From: Roger Spencer
Sent: 21 November 2017 16:31
To: Planning.Responses
Subject: RE: Planning Consultation on: FP/268/17/PL

The following is a response particularly in respect of coastal defence.

APPLICATION **FP/268/17/PL**

Description of Works: Detached 9No. bedroom annexe for Beachcroft Hotel with
9No. car parking spaces.

Figure 4 Sketch Elevation to Promenade

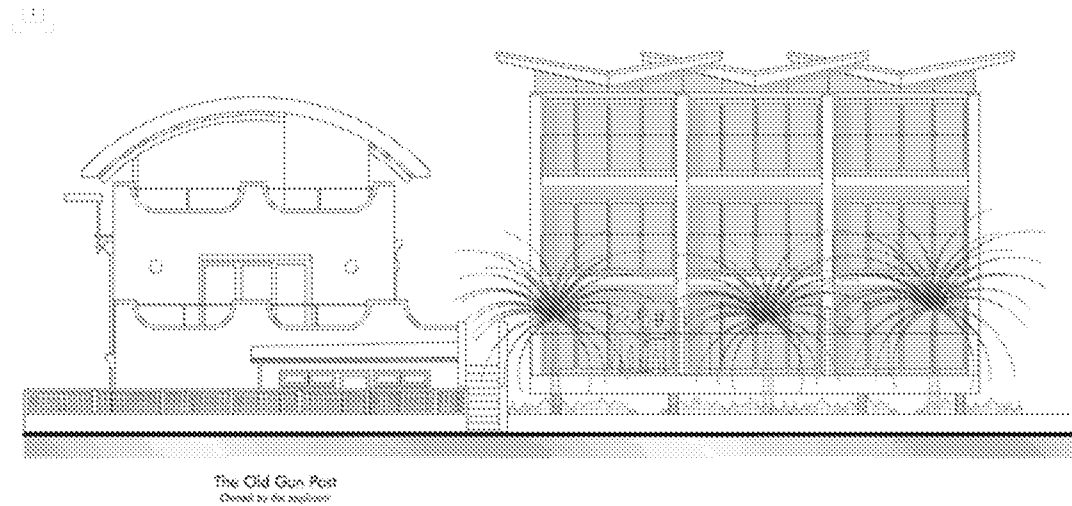
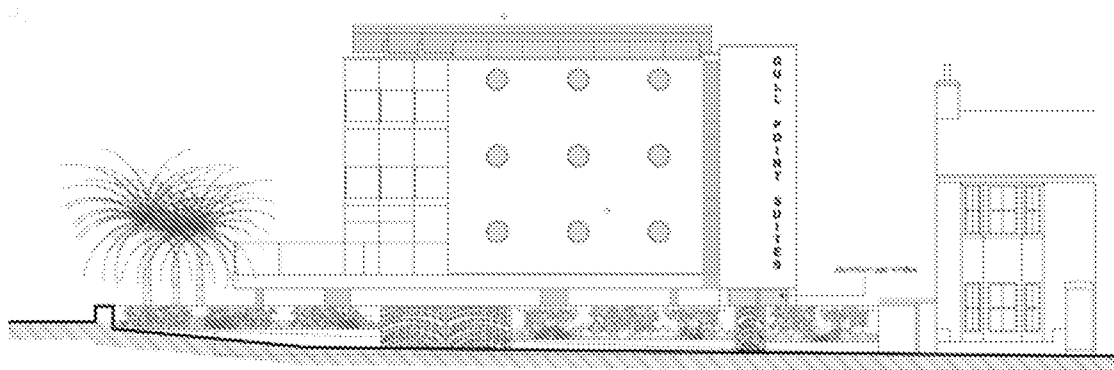
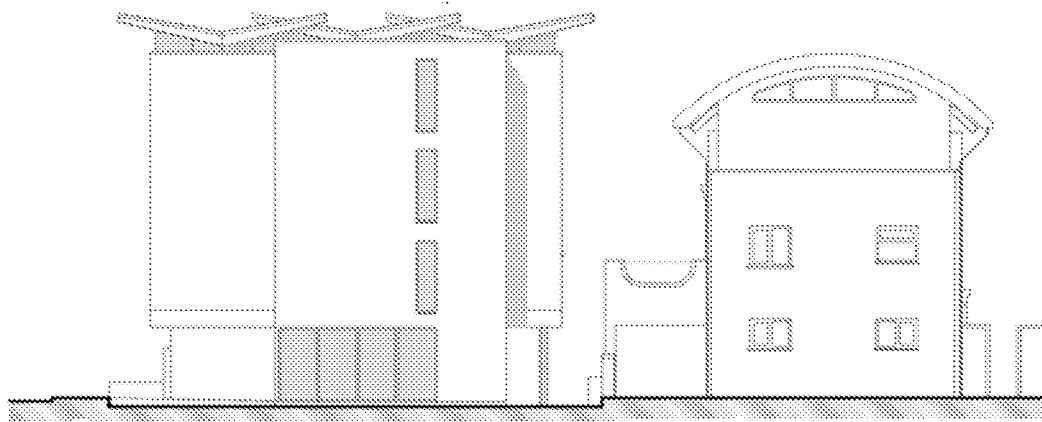
Further, I feel that the 'rendered lightweight superstructure' may not be substantial enough to resist the harsh coastal environment; there would also seem to be scope for water ingress unless the detailing is of the highest quality. I also understand that Building Control colleagues have provided some advice (means of escape / fire resistance/etc.) therefore all of the forgoing assumes that the development will have comply with Building Regs etc.

Low Timber Wall (Elevation)

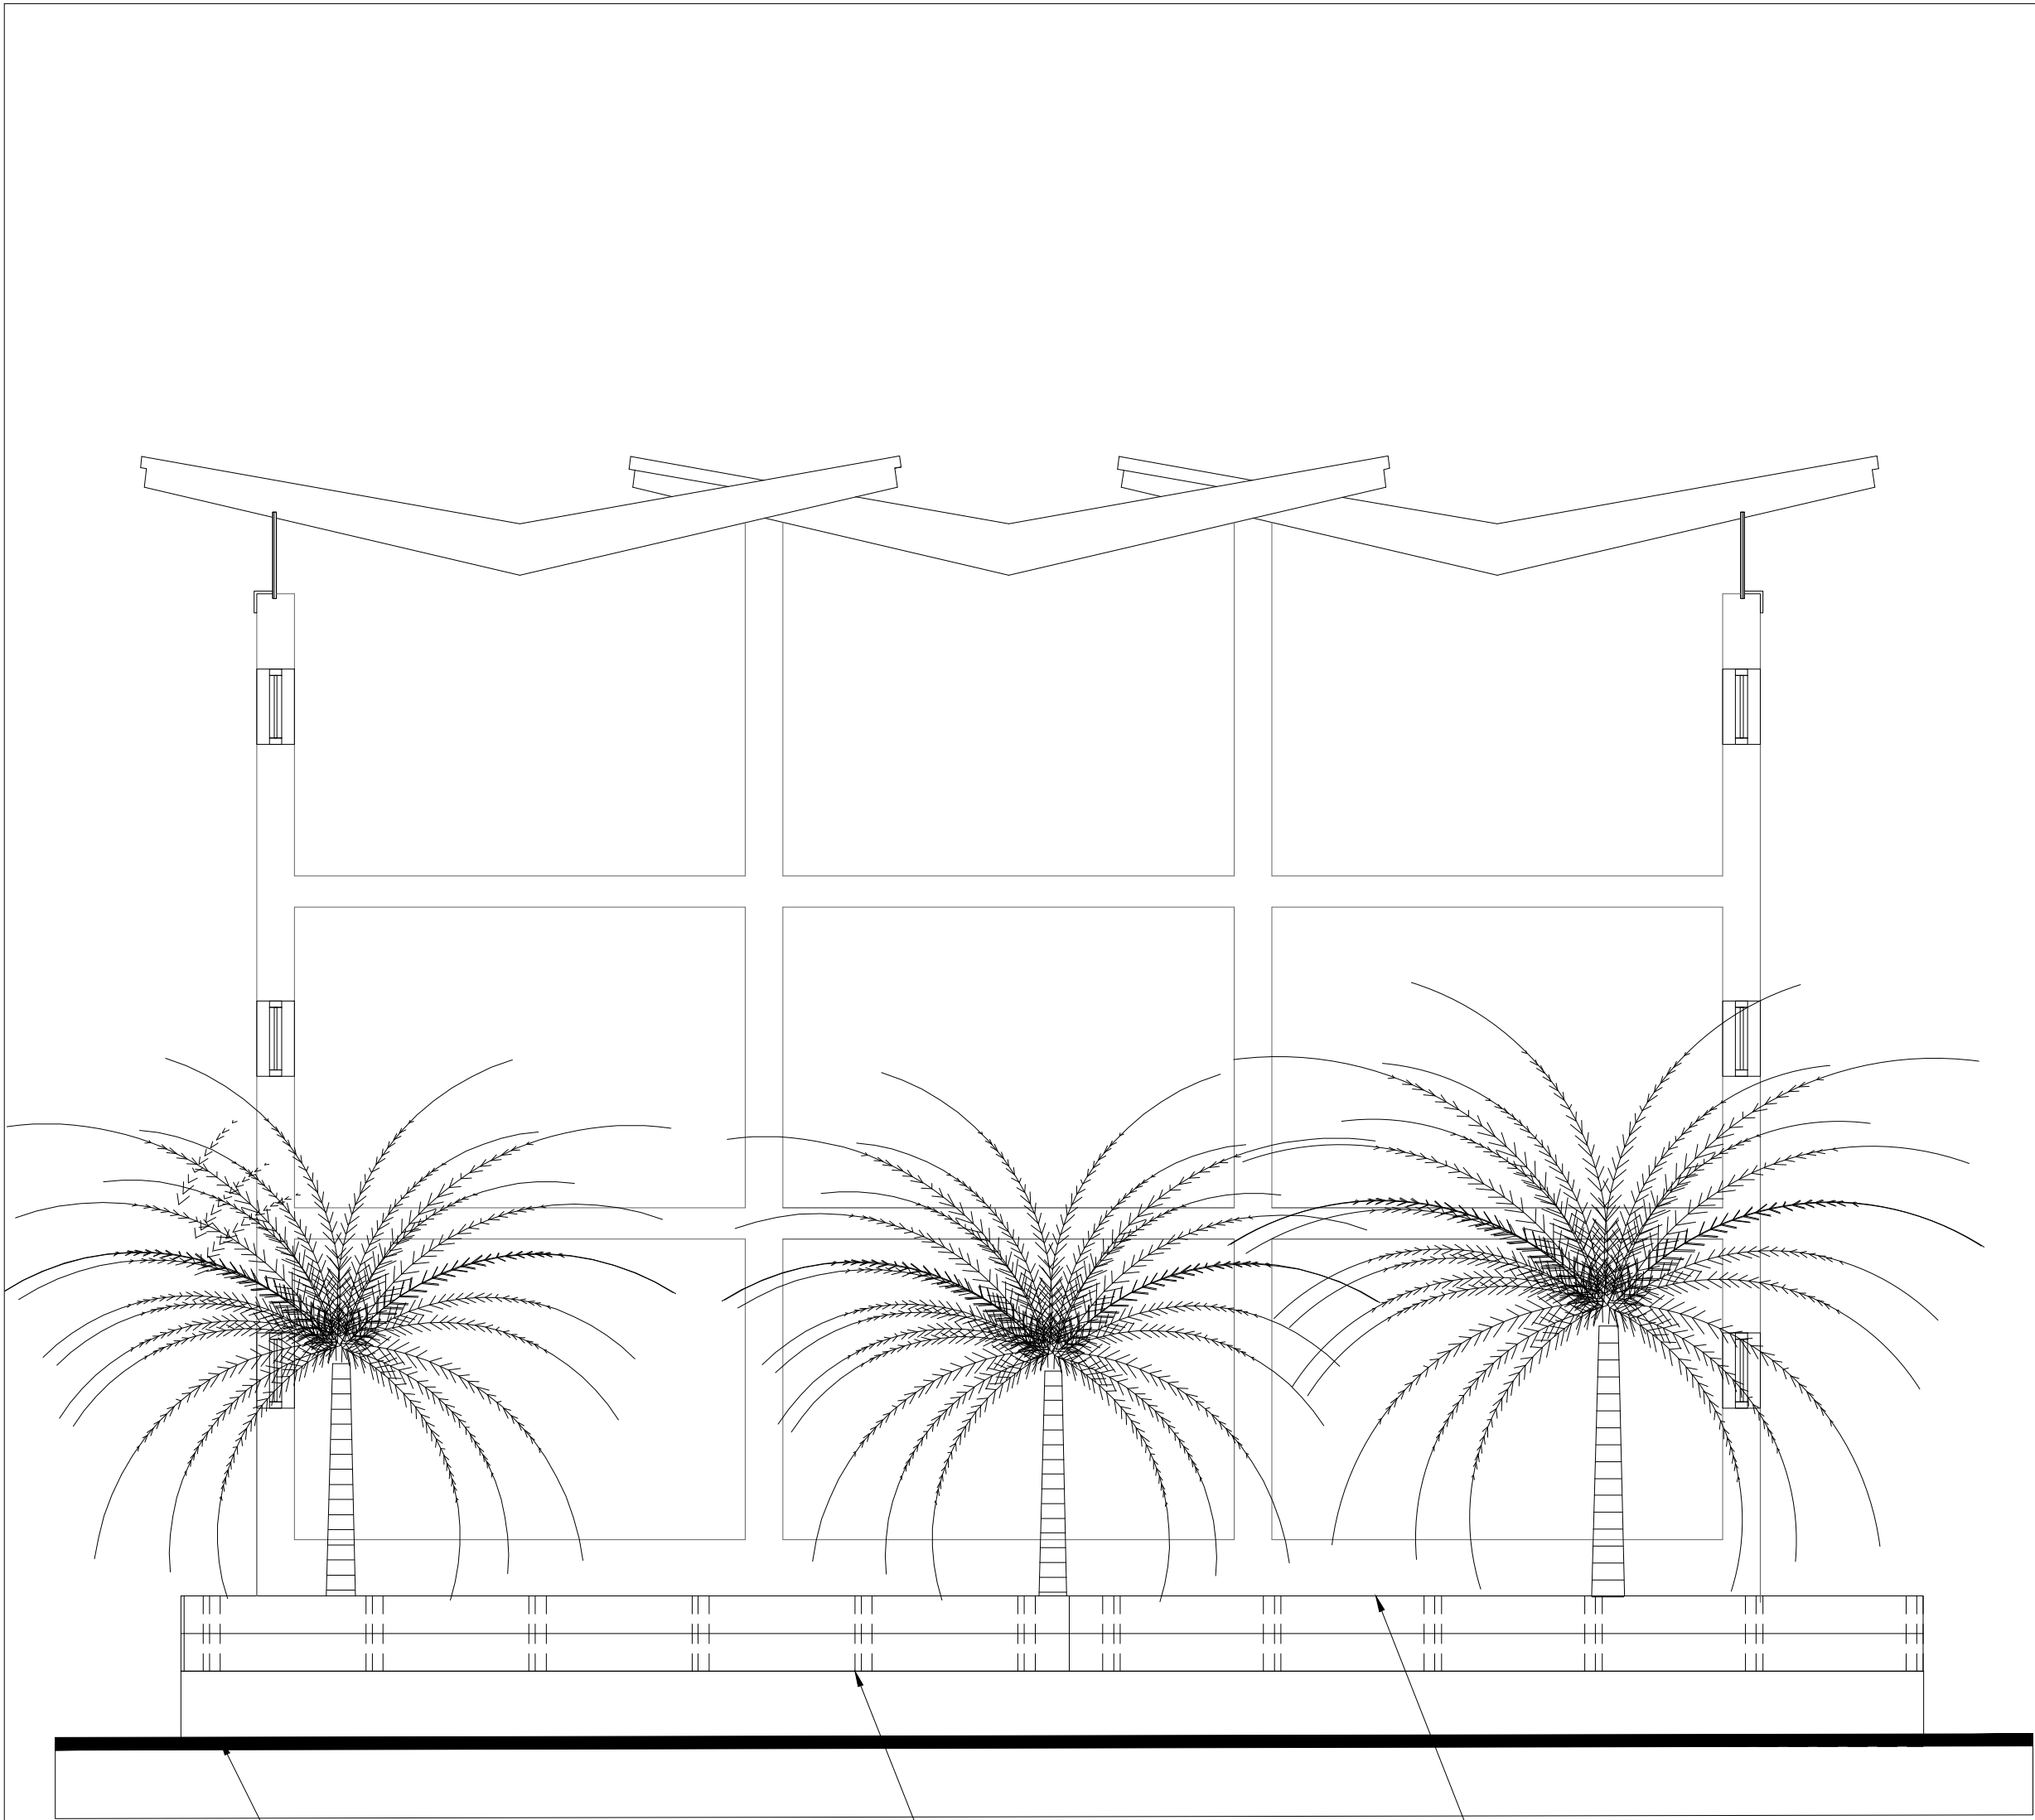
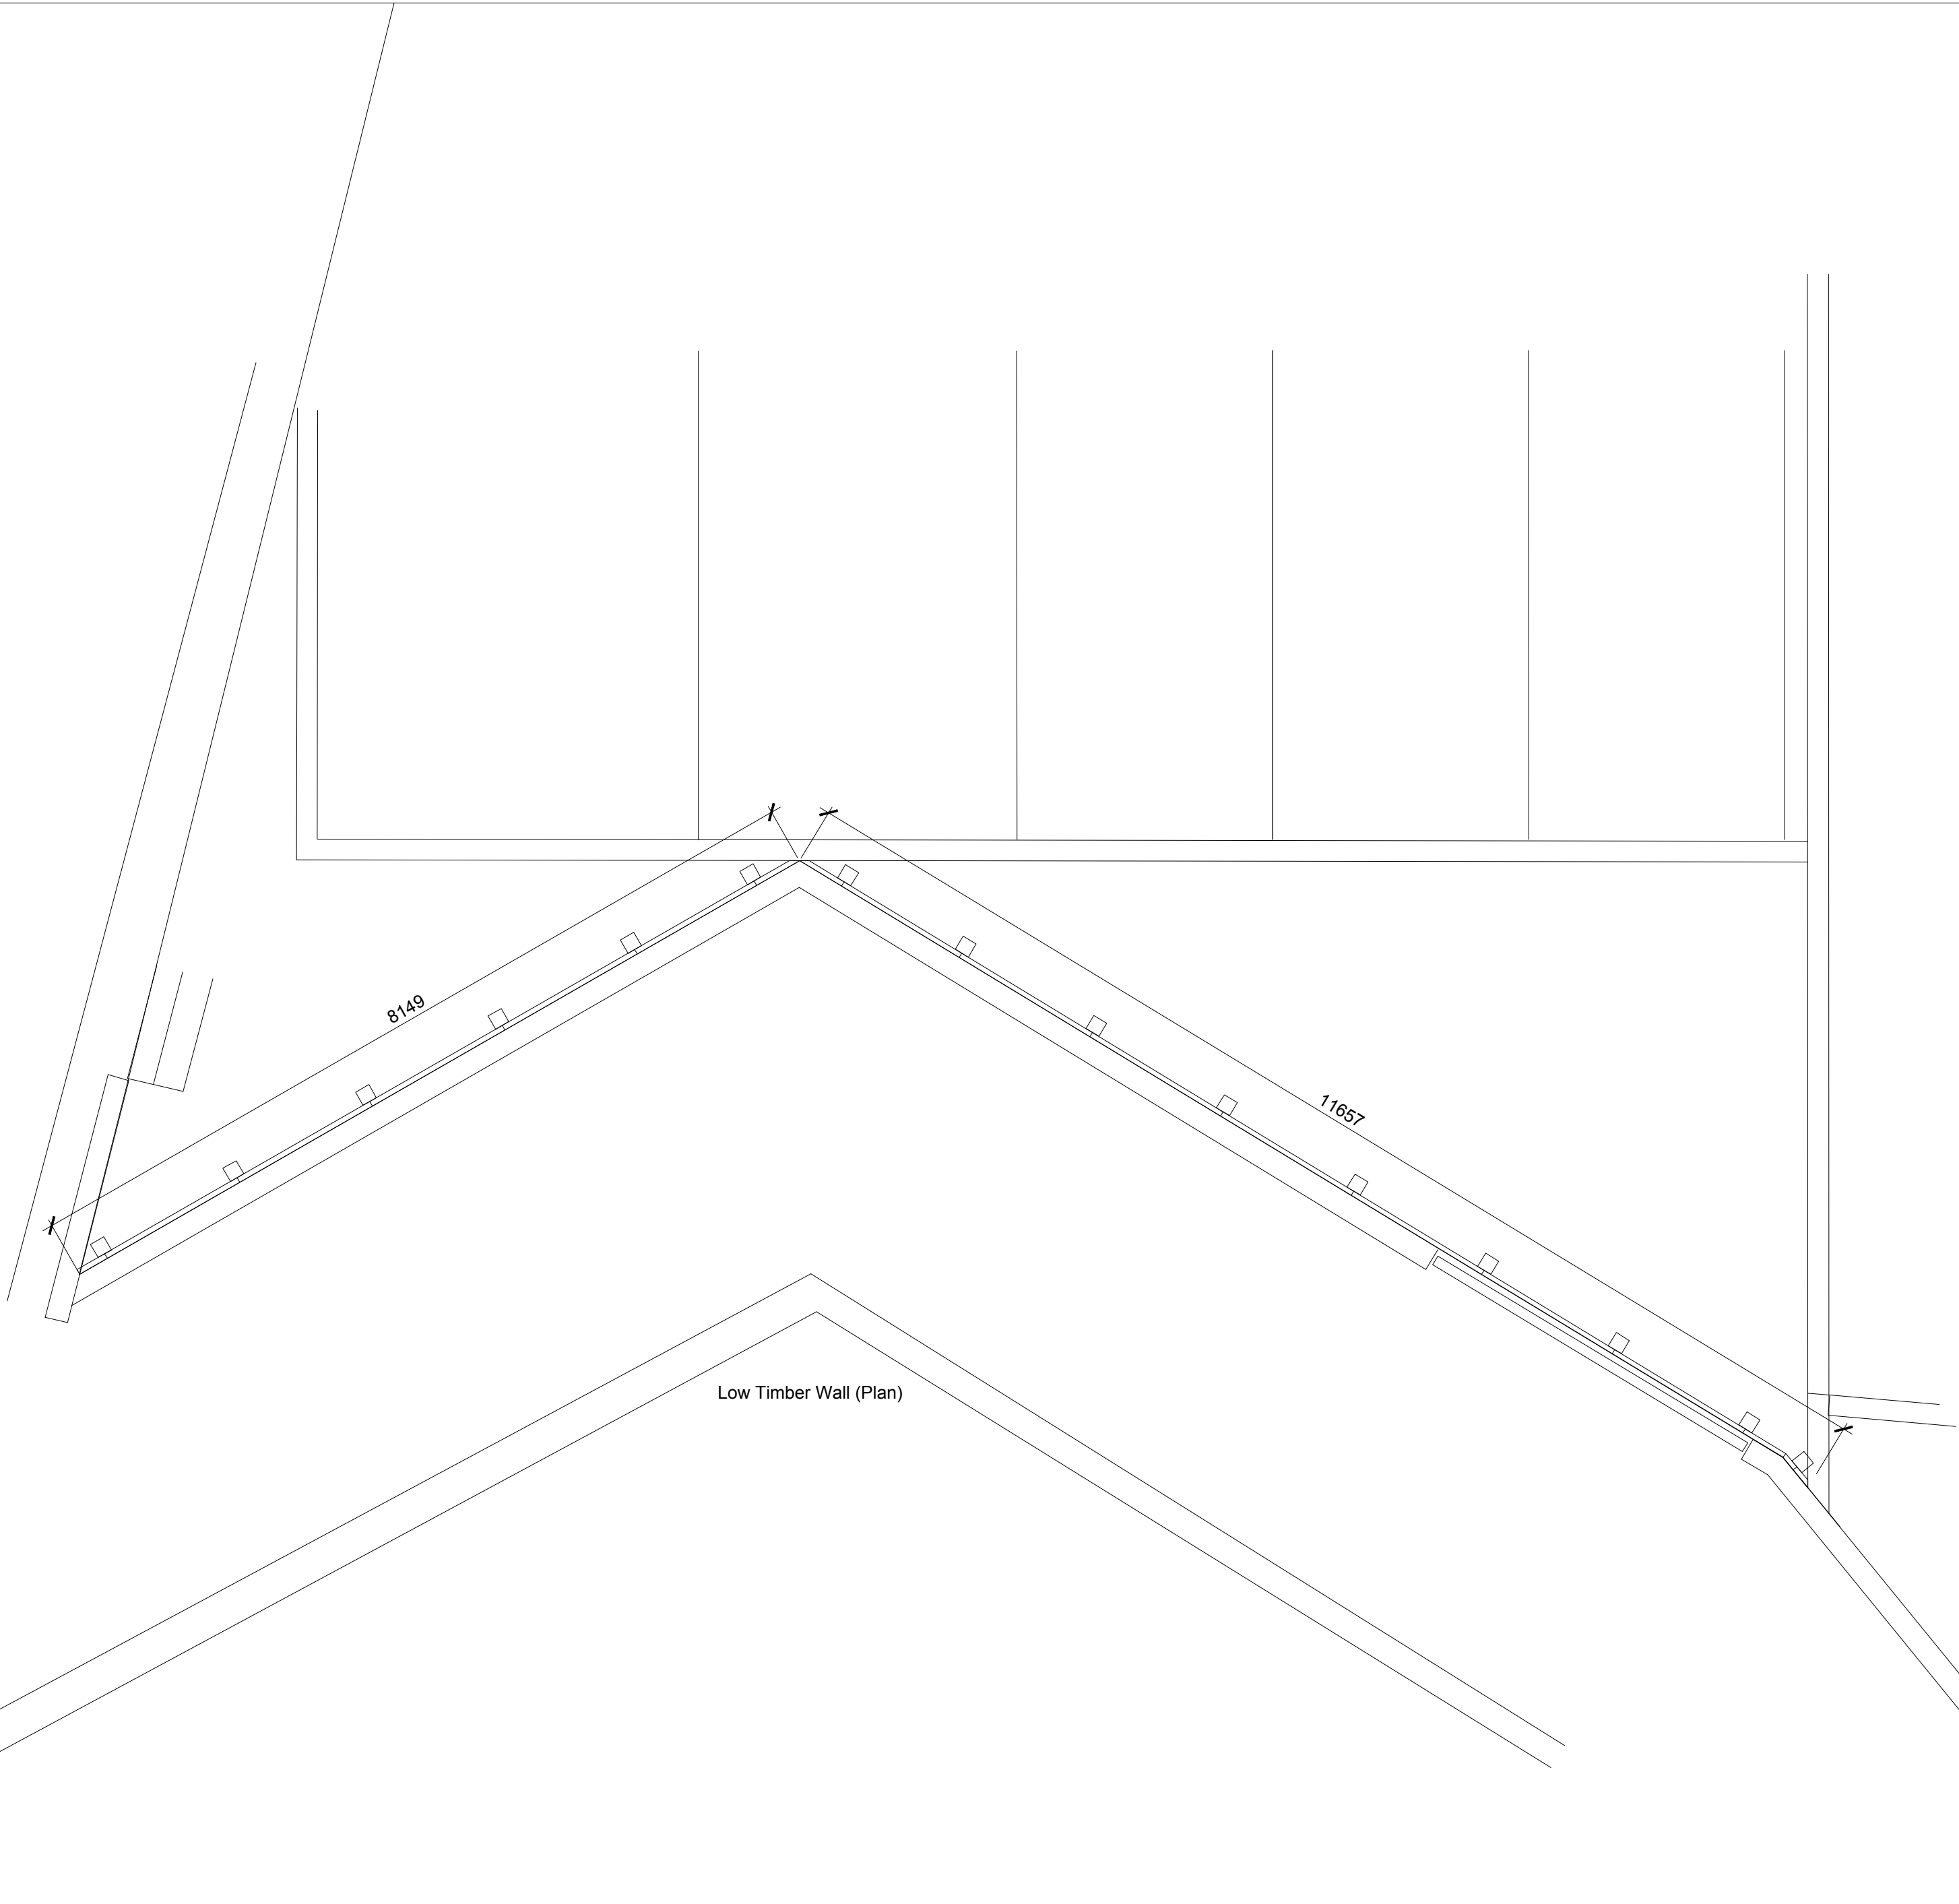
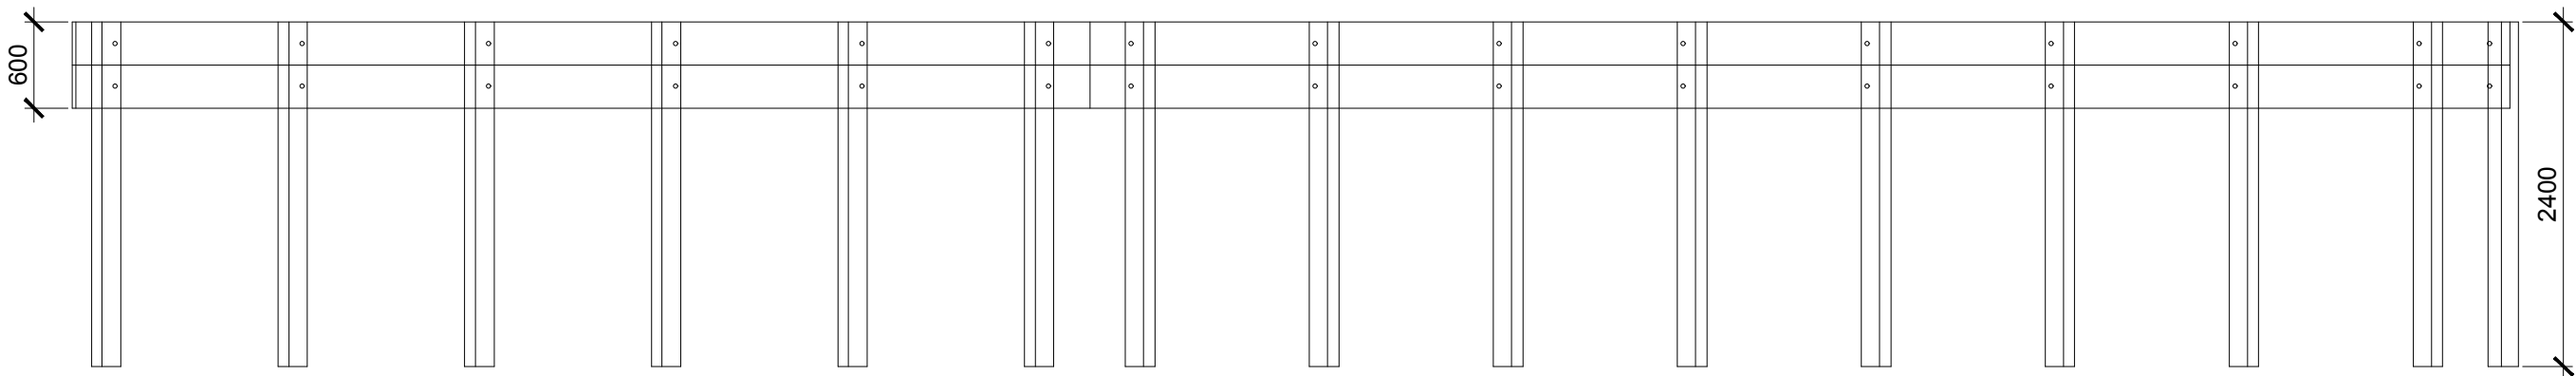
The site is immediately adjacent to the rear splash wall of the coastal defence; that rear splash wall has an access through it which is currently provided with 'stop logs' to reduce the risk of water and shingle entering the site.

I appreciate the fact that the ground floor will be undercroft car parking and therefore there is low risk. However, there is a history of shingle over-wash into the site. Most recently, the stop-logs were damaged which resulted in further shingle deposition within the site.

I would suggest that the development be provided with a higher, more robust and continuous eastern boundary feature to reduce the risk of shingle and water over-wash into the site. This may reduce lighting levels in the undercroft but it would not detract from views afforded to the suites.
